**Application for Planning Permission and for relevant demolition of an unlisted building in a conservation area
Town and Country Planning Act 1990**

CHANGE OF USE FROM CHURCH TO 4NO. STUDIO FLATS AND WORKS TO REAR ELEVATION

Assuming no specific problems are brought to light we are optimistic that the application for the conversion of Seventh Day Adventist Church, 106 Sackville Street could be looked upon favourably.

NORTH-SOUTH CROSS SECTION

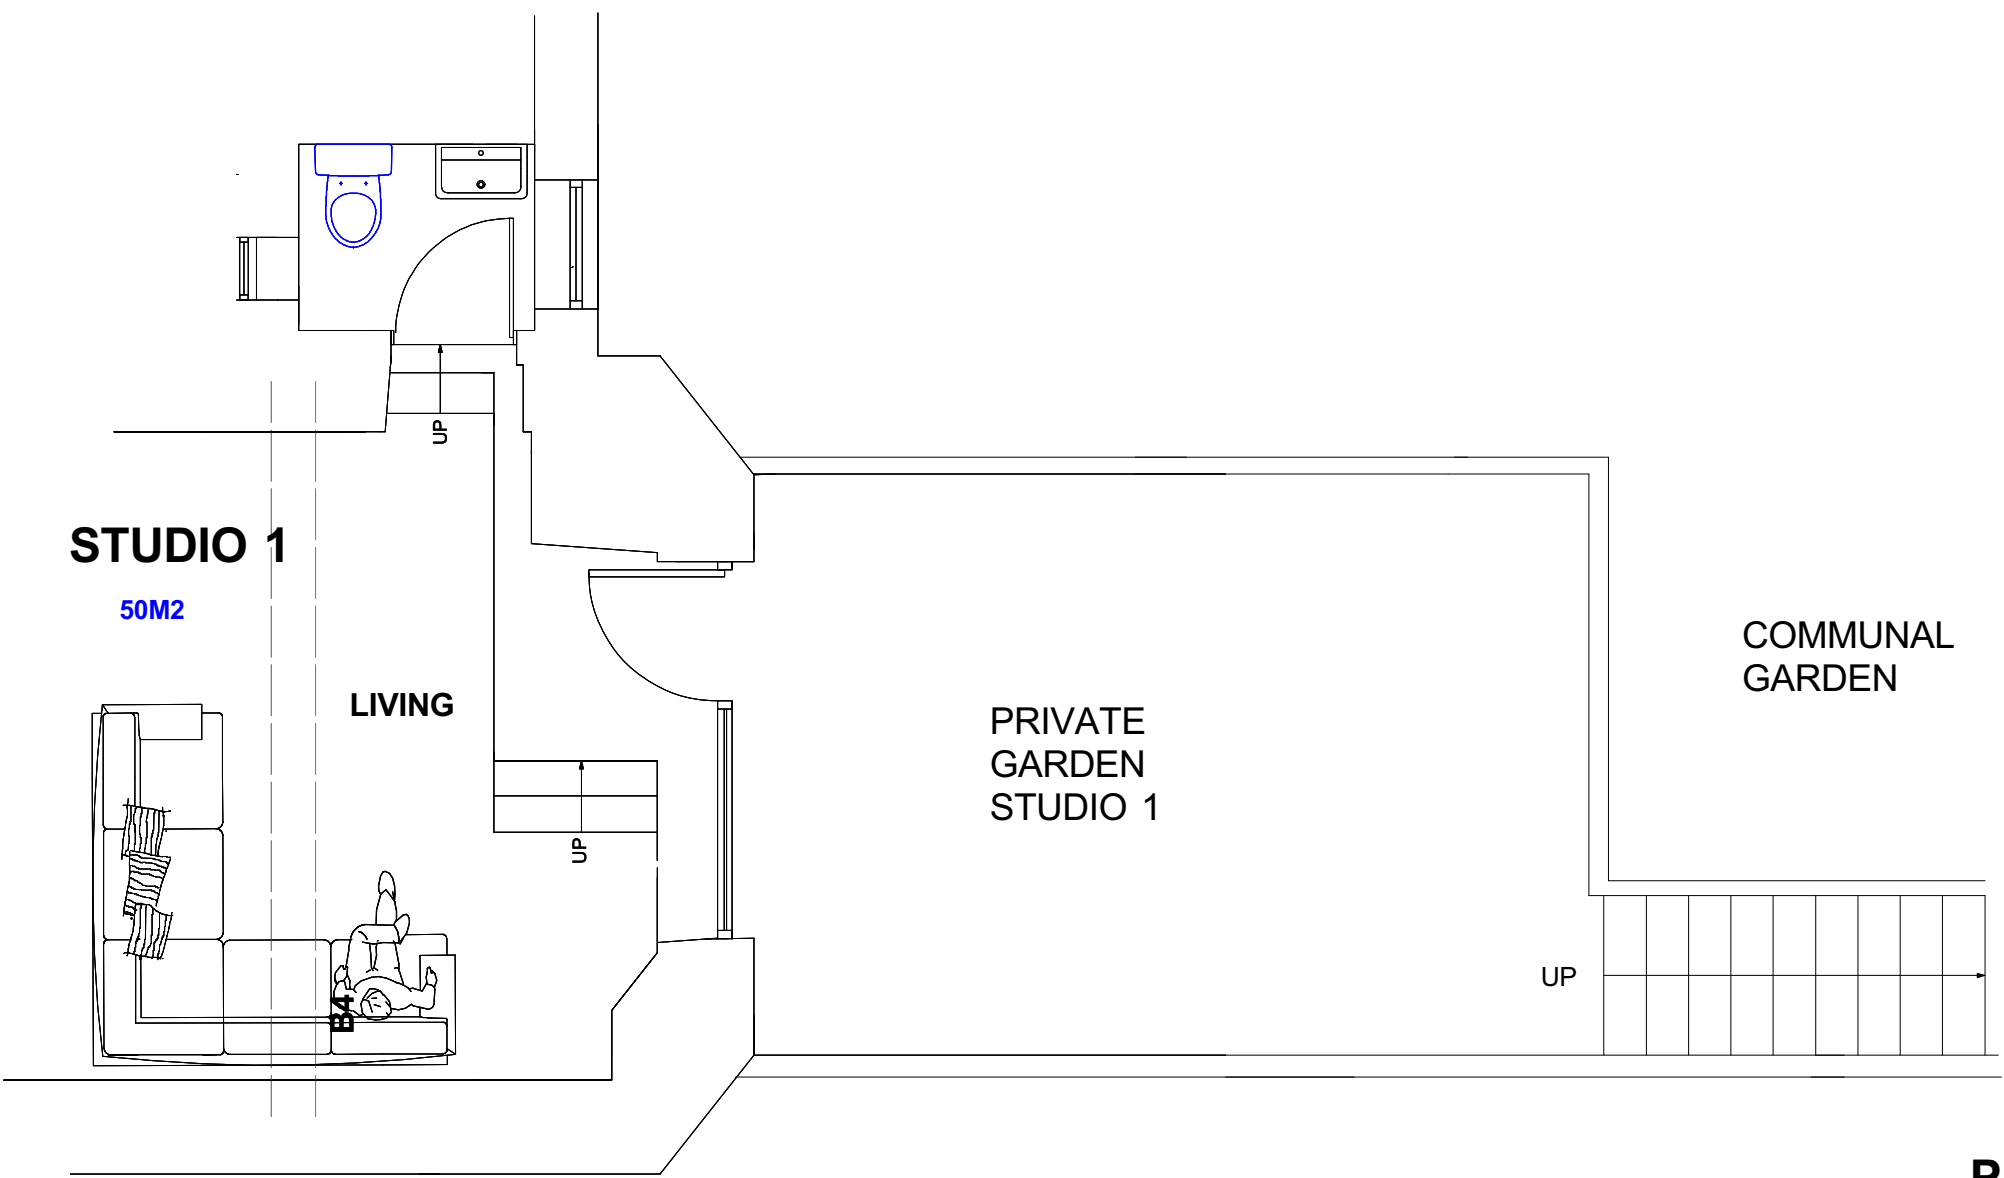
Whilst I believe that my concerns have been met in relation to the residential amenity issues regarding studio 1, by the removal of the external staircase and a reduction of the external floor levels in the garden. I would like to see some addition details, such as a cross section showing the cut away land.

refer to my cross section as requested

Studio 1 will be flooded with natural light from the south

elevation, full height window and cut away land..

Studio 1- We propose to remove the external staircase and reduce the external floor levels in the garden. The outlook to the garden area will then be acceptable

Second Floor - Refer to the cross section - the floor level has been reduced -

we now achieve a 38m2 studio
